Notification for Prior Approval for a Proposed Change of Use of a building from Office Use (Class B1(a)) to a Dwellinghouse (Class C3) to provide 30 self-contained flats (14 studios & 16 one-bed flats)

4 Hawthorn Road Littlehampton

Thank you for your internet representation made on 14th November 2018 which has been recorded as '**an objection**' with the comments as follows:

GROUND FLOOR PLAN

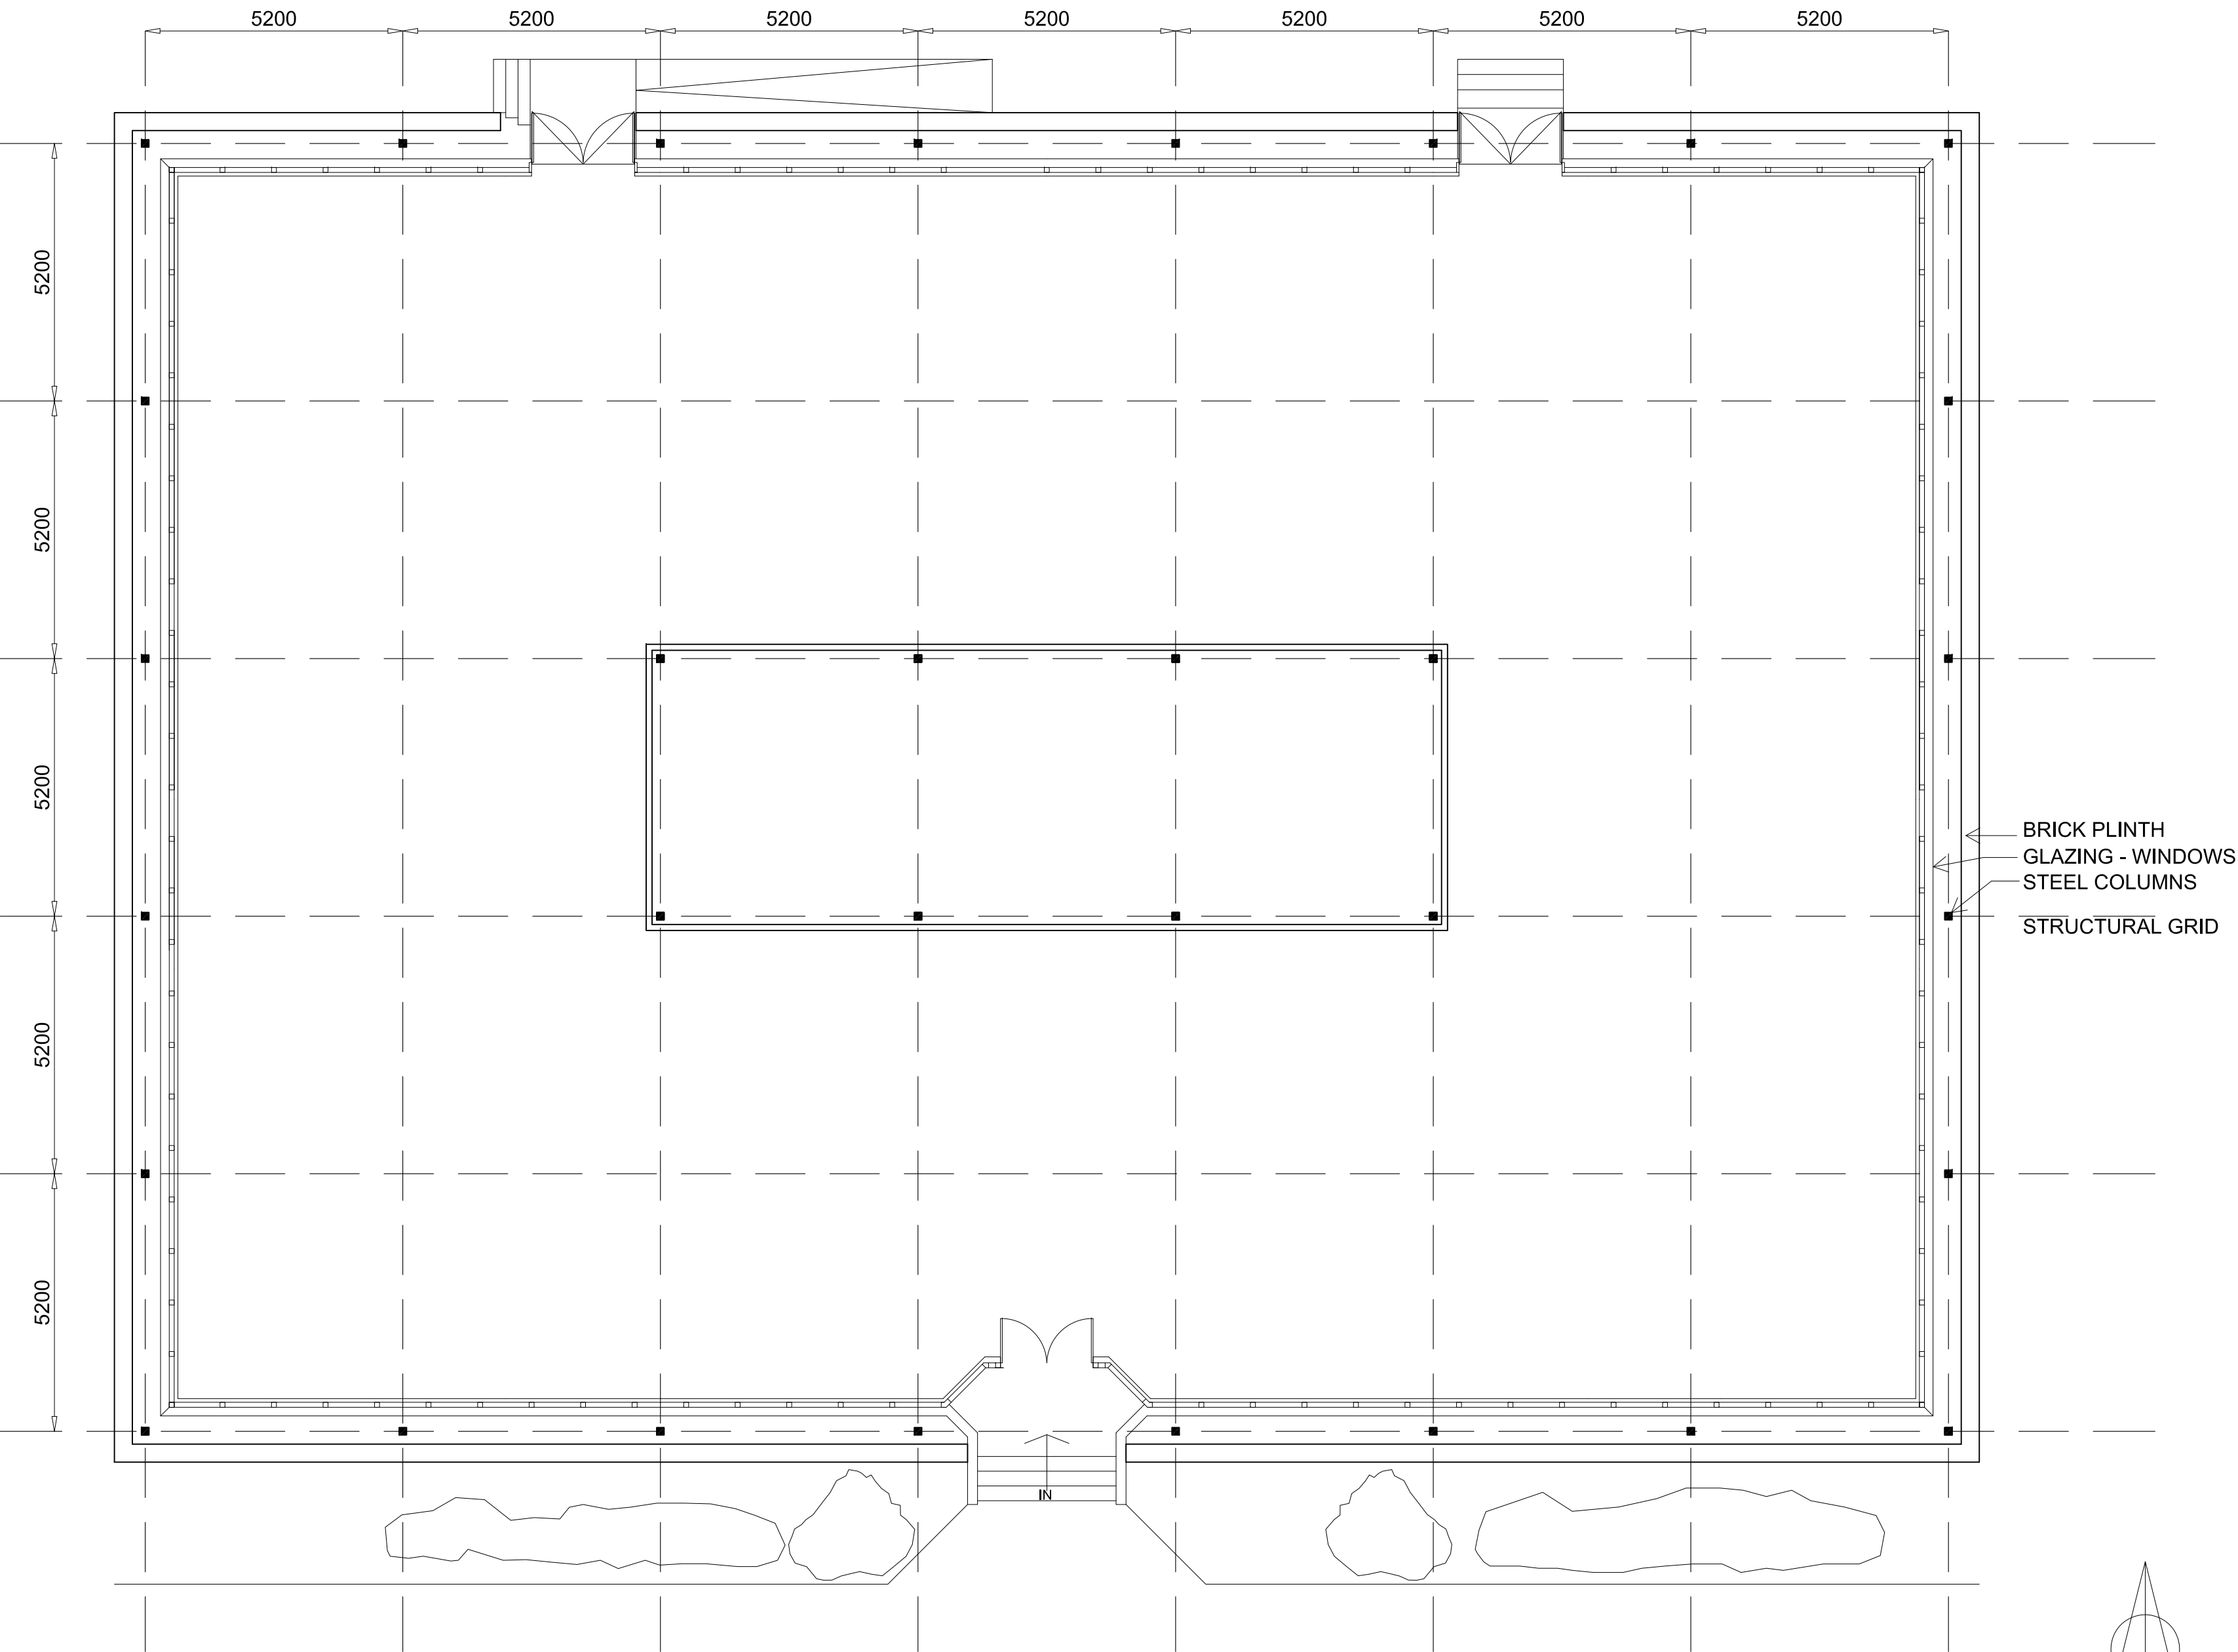
In terms of relevant material planning considerations, it was also considered that the that noise and disturbance from both the surrounding industrial units and the A259 would have an adverse impact on the amenity of future residents and that the site generally was not suitably safe particularly for families with young children. Members also questioned the veracity of the information provided in support of the application in relation to the transport statement regarding bus routes and the sufficiency of drainage provision. With this in mind, the Committee also therefore considered that proper consultation with Southern Water would be necessary to ensure that demand could be catered for. In addition, the proposals lacked amenity space and it was observed some of the dwelling sizes were below the national minimum standard for 1 bed 1-person dwellings.
